1 VALLEY VIEW
GREAT BOURTON
BANBURY OXON
OX17 1QJ

17TH SEPTEMBER 2020

PLANNING APPLICATION 20/02060/F -- THE STABLES MAIN STREET GREAT BOURTON OX17 1QU

# SITE LAYOUT PLAN

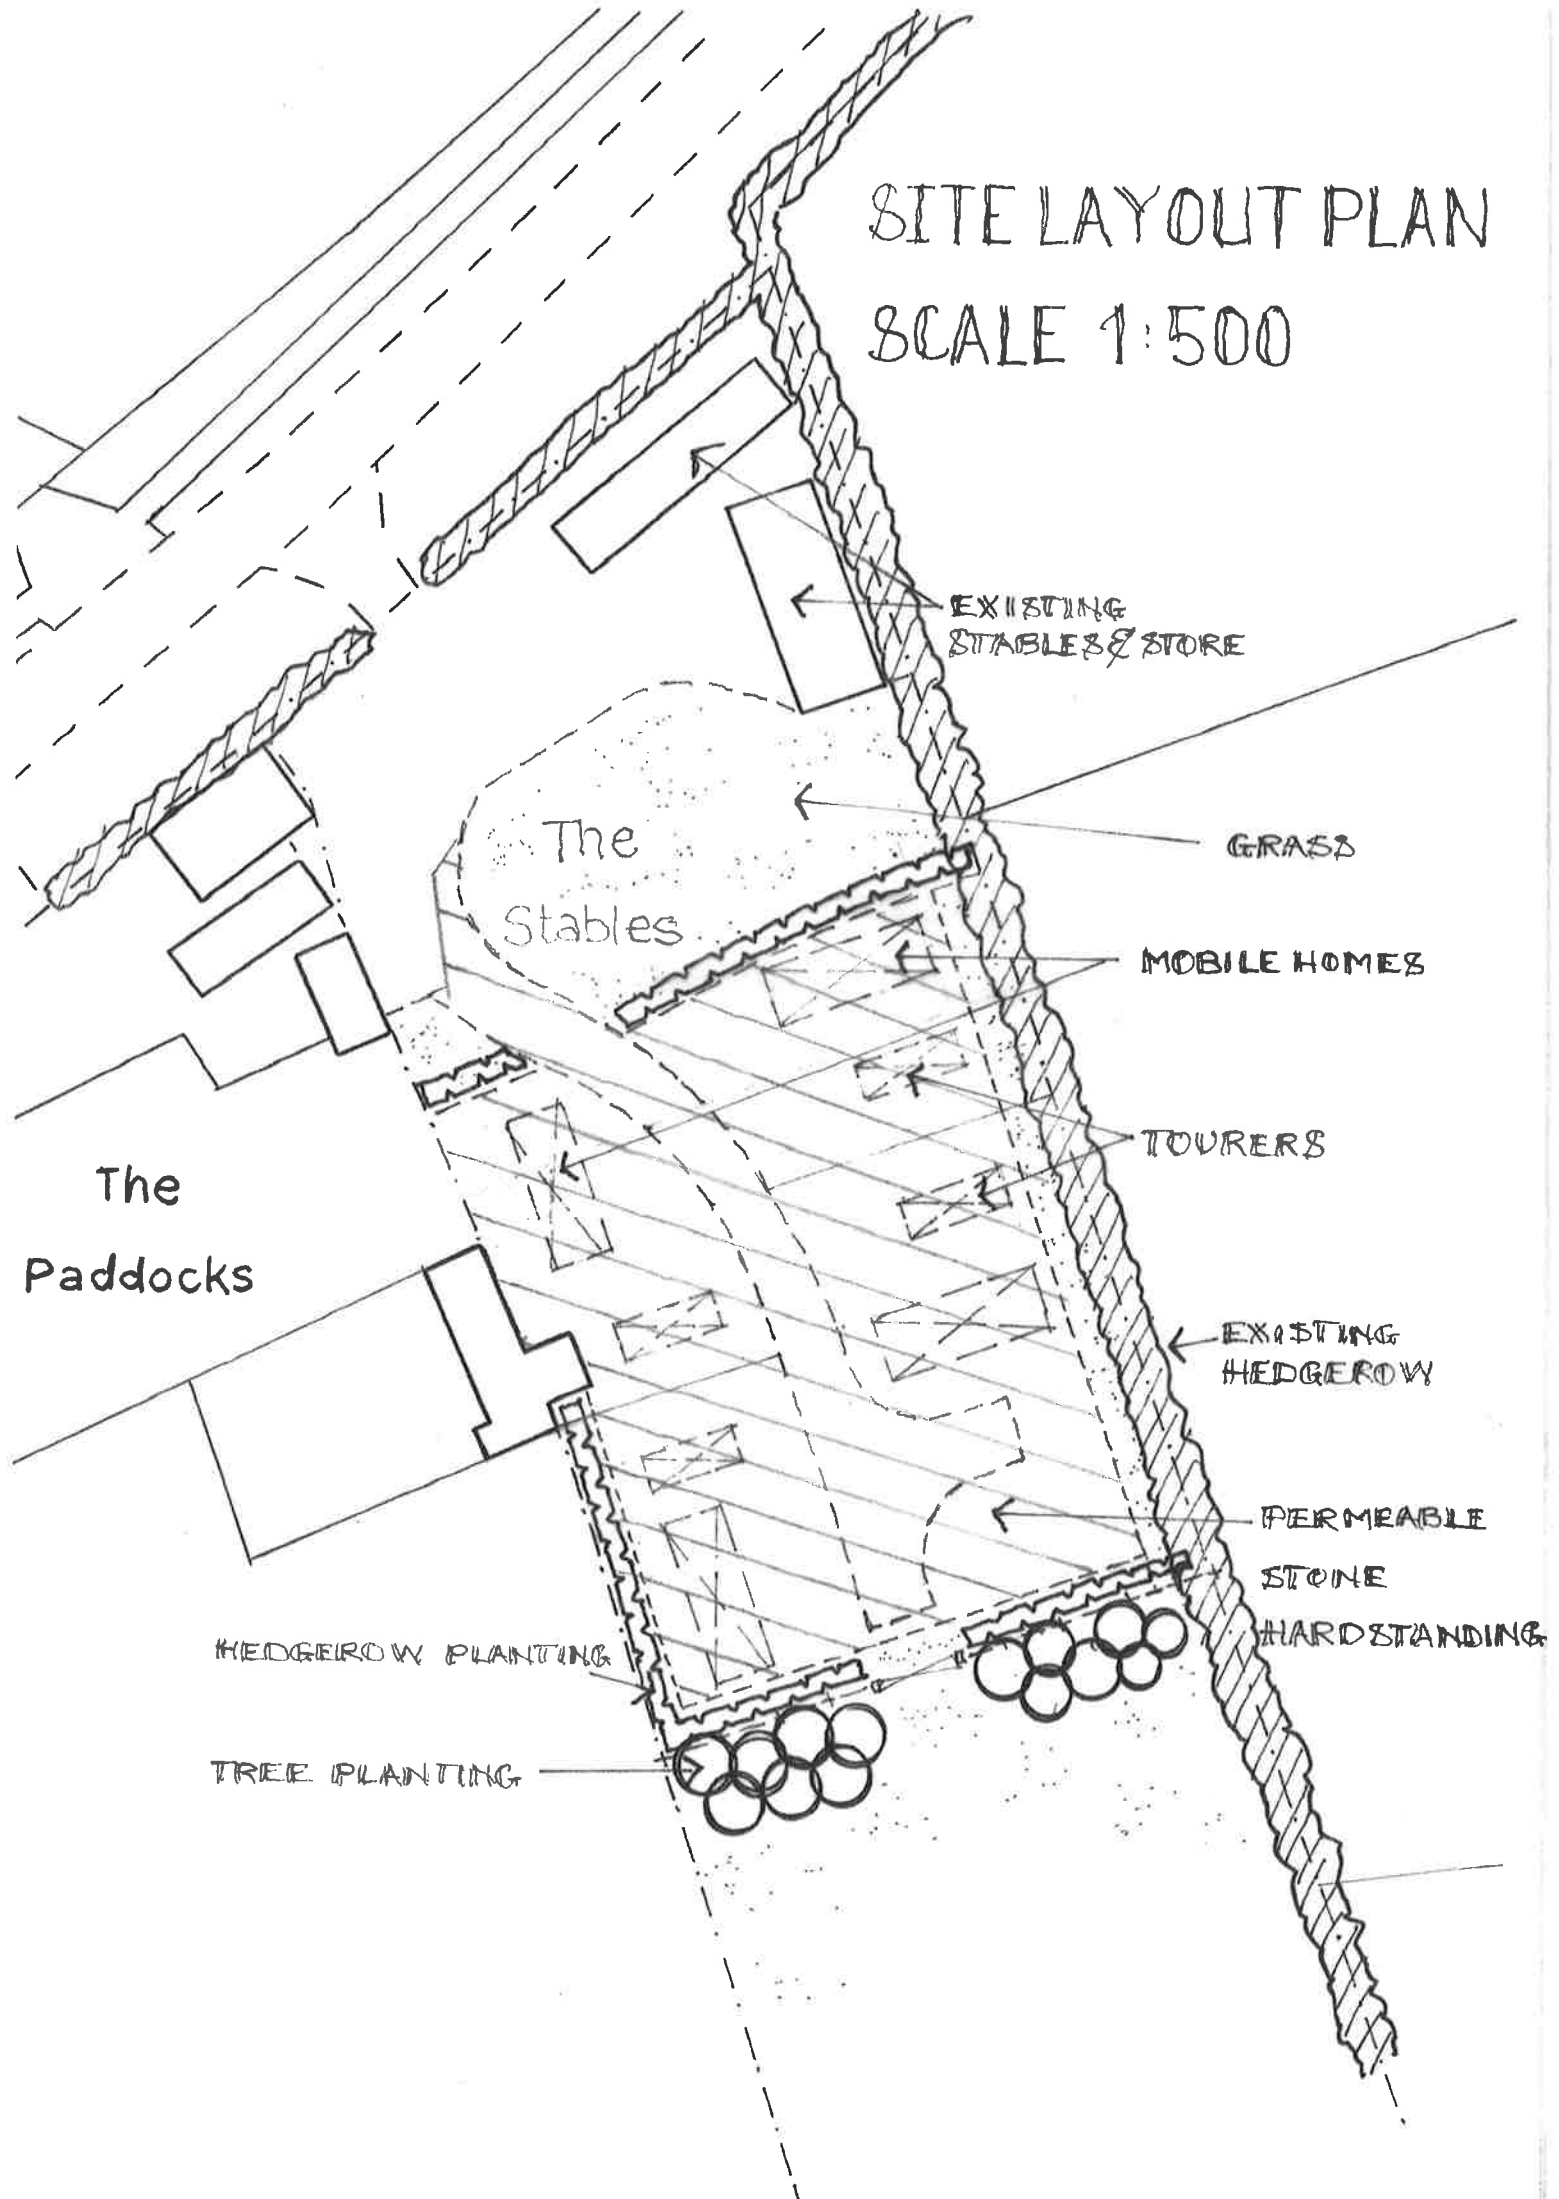
The proposal seeks for a change of use of the land from agricultural to Gypsy and Travellers pitches numbering 4 static vans plus 4 tourers vans. Past local experience suggest that this would be just a start of a significant development of expansion and density, as it would appear that the adjacent field marked blue on the site location plan is in the ownership of the applicant also.

We also wonder what will happen to the public footpath that at present transects the site and was conveniently omitted from the submitted site plan.
